From: [Bryan Bobrick](#)
To: [Harmon Rita T.](#)
Subject: Re: FW: Following up from Friday regarding Penguin Chill plans
Date: Friday, October 07, 2016 11:33:42 AM
Attachments: [image001.png](#)

Please see the attached approval letter from Hydrology, pending a condition that WUA will accept the drainage from the trench drains.

TRENCH DRAIN IN RAMP TO LOWER LEVEL

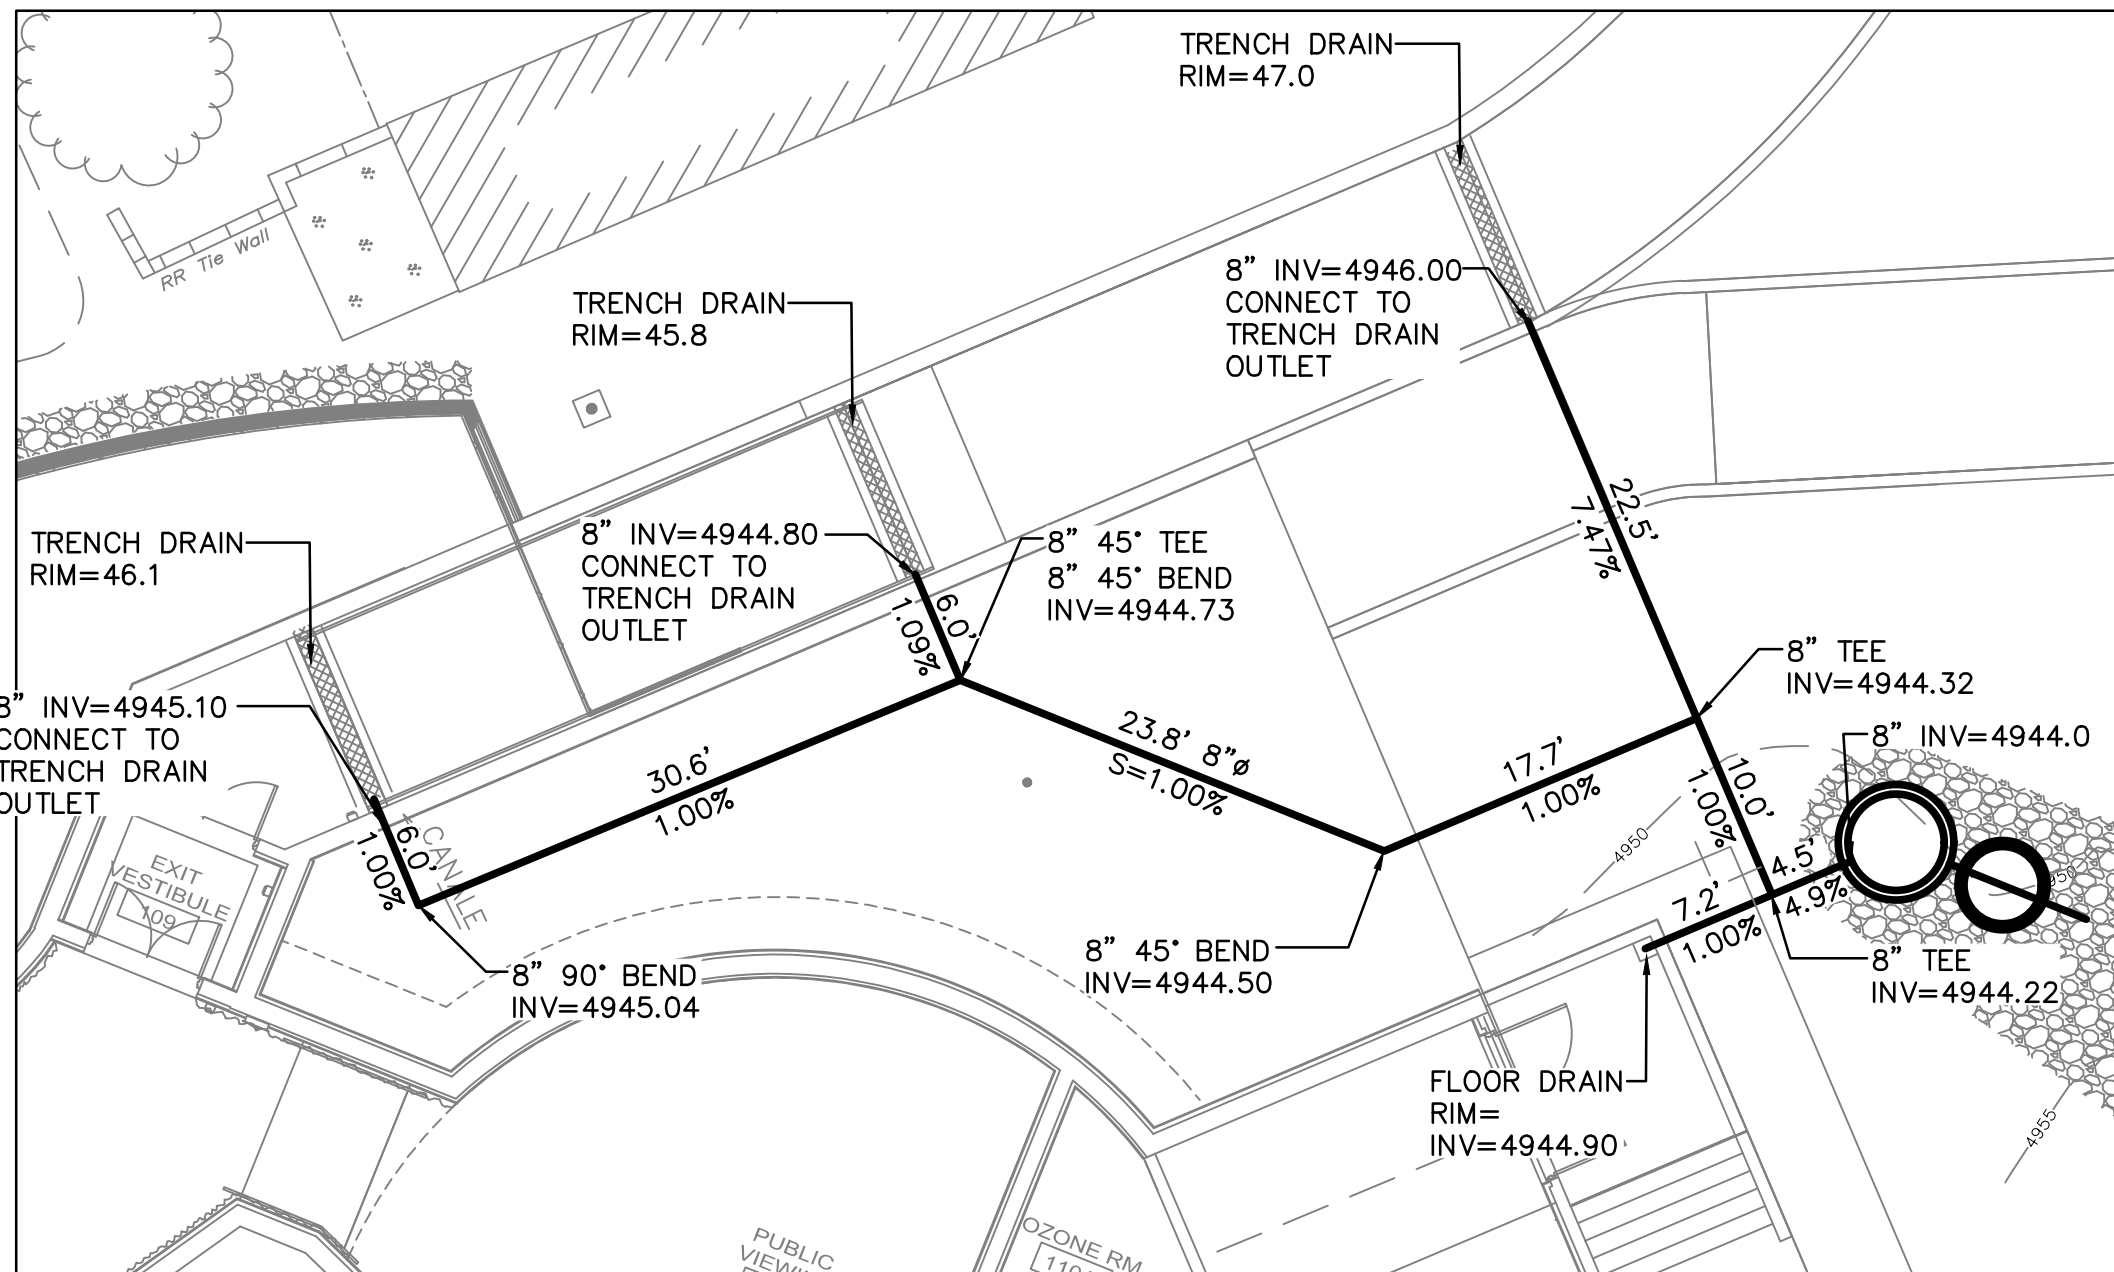
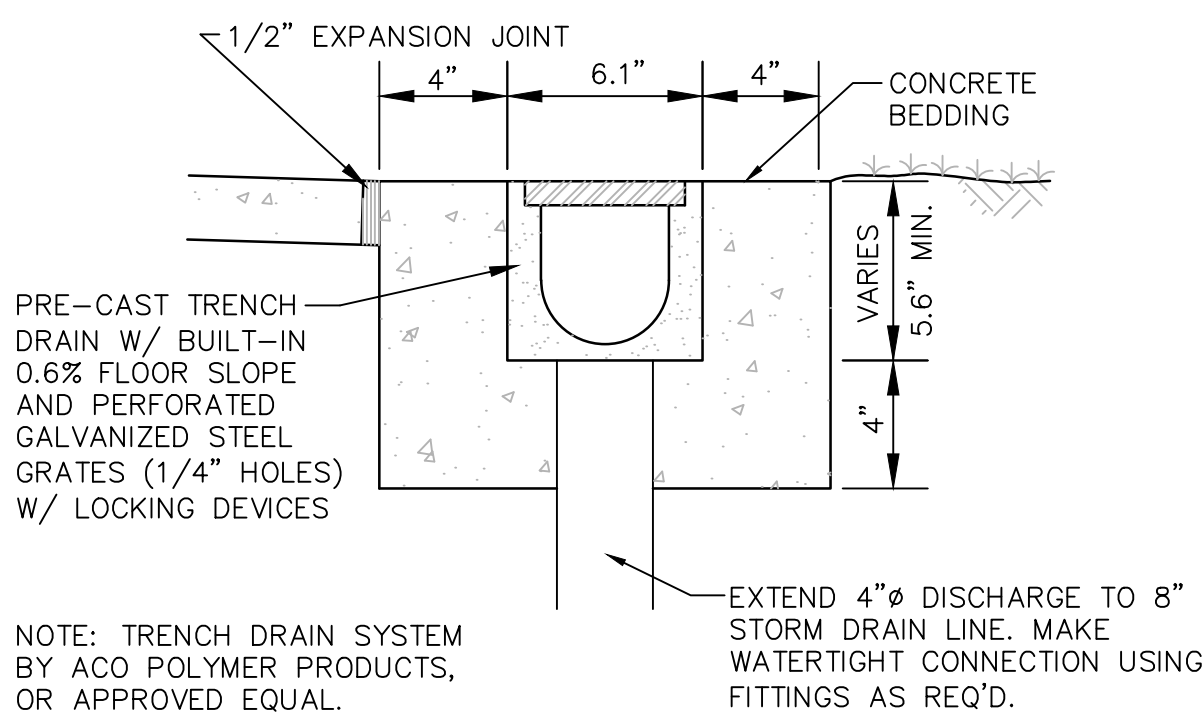
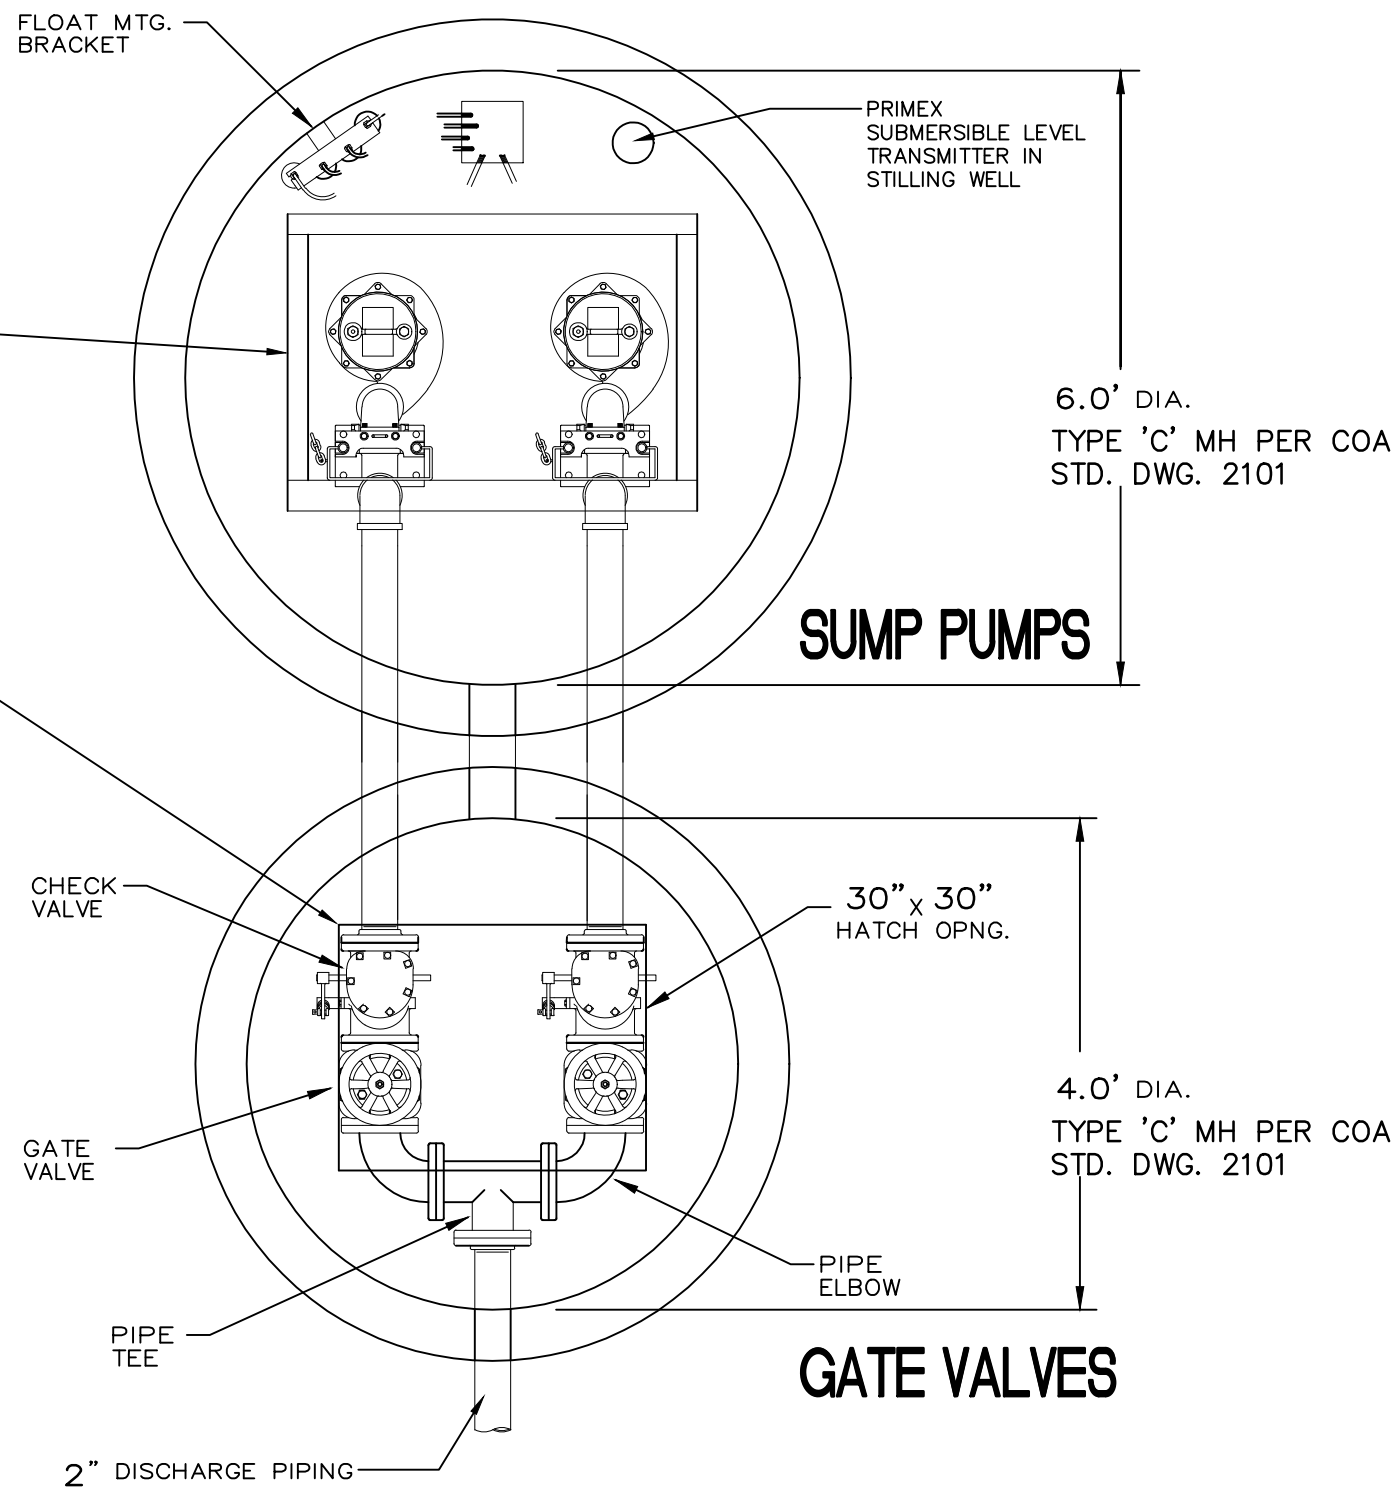
If it is a no-go, then just add the pump scheme to the As-built plan/ Eng. Cert. Plan.

Great - thank you Rita - we are in the process of coordinating with Jane. If it's a no-go, we would need to come up with a sump pump solution that would pump to grade so it shouldn't impact the approval - one way or another, we'll get the water out.
